OBSERVATION/SUBMISSION TO PLANNING APPLICATION

Case Reference: 324113

Re: Observation to the proposed development of open-cycle gas turbine (OCGT) and generator with ancillary equipment.

Location: Pollnagroagh and Rathmorrissy (Townlands), Athenry, Co. Galway

Purpose		PLANNING			
Title		SITE ACCESS SIGHTLINES			
Original Scale	Design/Drawn	Checked	Authorised		
SHOWN at A1	PS	ND	AJB		
Date	Date	Date	Date		
01.12.25	01.12.25	01.12.25	01.12.25		
Status	Drawing Number	Rev			
A2	PEK3-ATK-ZZ-01-DR-CE-901200	0

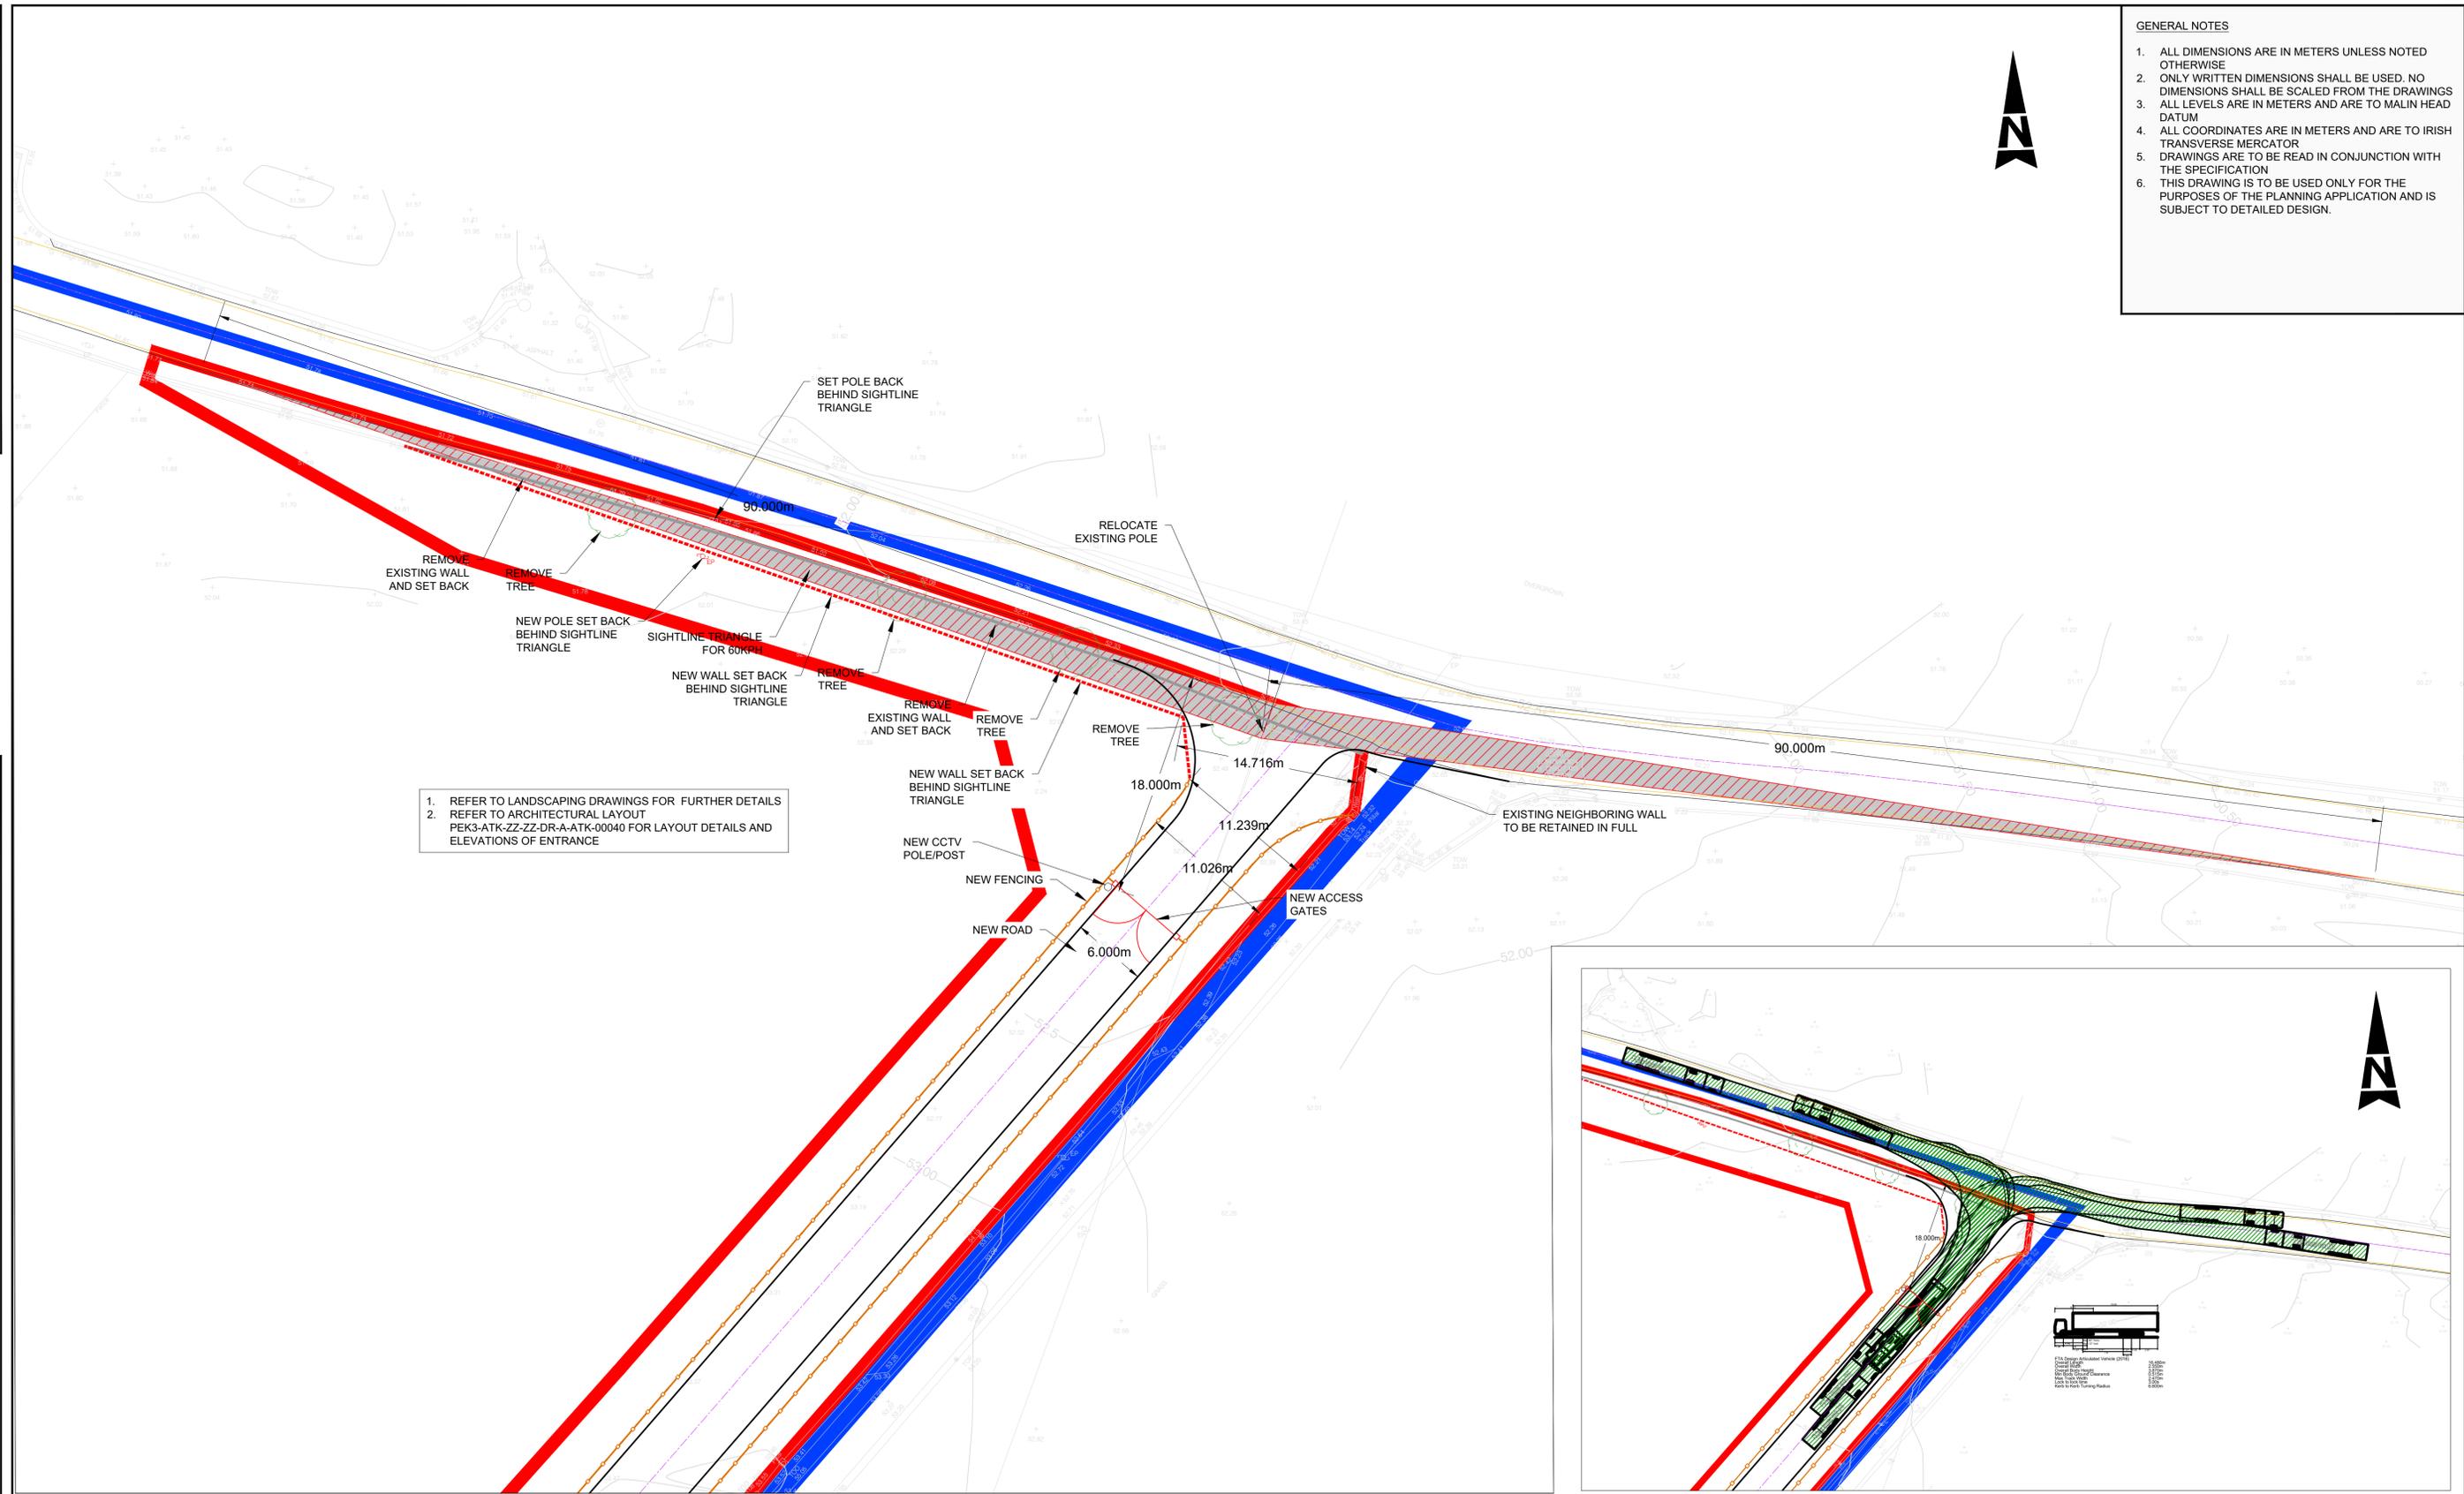
As someone who lives locally and uses this road, I am concerned about road safety in relation to the proposed entrance on the L3103. This stretch of road is already extremely narrow, with no hard shoulder, making it difficult for two heavy goods vehicles to pass safely and leaving no margin for error. Visibility is also poor due to blind dips and sharp bends, meaning drivers often cannot see oncoming traffic in time. The proposed development would increase traffic levels, including heavy goods vehicles, construction traffic, and fuel deliveries such as diesel tankers, all of which require space and clear sightlines that this road does not provide.

As someone who lives locally and extensively uses this road, I am concerned about the proposed location of the site entrance on the L3103. This section of road is already extremely dangerous, as it is narrow, has no hard shoulder, and does not provide sufficient space for two heavy goods vehicles to pass safely. Visibility is also poor due to blind dips and sharp bends, meaning drivers often cannot see oncoming traffic in time, and introducing a site entrance at this location would significantly increase the risk to all road users.

There are serious concerns about the proposed site entrance on the L3103, which is an exceptionally dangerous stretch of road where introducing an access point would create an unacceptable level of risk. The road is extremely narrow and cannot safely accommodate two heavy goods vehicles passing at the same time, there is no hard shoulder to allow for safe manoeuvring or recovery, and visibility is severely limited due to blind dips and sharp corners. These are significant existing hazards that already pose a real danger to road users, and the addition of a site entrance would further increase that risk.

The placement of a site entrance at this hazardous location on the L3103 raises serious safety concerns. The road is already constrained by its narrow width, the absence of a hard shoulder, and extremely poor visibility due to blind dips and sharp corners, yet the Environmental Impact Assessment does not appear to fully address the safety implications of introducing an access point at this location. There are also concerns that the cumulative impact of additional traffic has not been properly assessed, including construction traffic, ongoing operational traffic, and fuel deliveries, and the interaction between heavy goods vehicles and existing road users—such as local traffic, school-related movements, and agricultural machinery—has not been examined in sufficient detail. Overall, the lack of a thorough and robust traffic safety assessment creates significant uncertainty as to whether the local road network can safely accommodate this development.
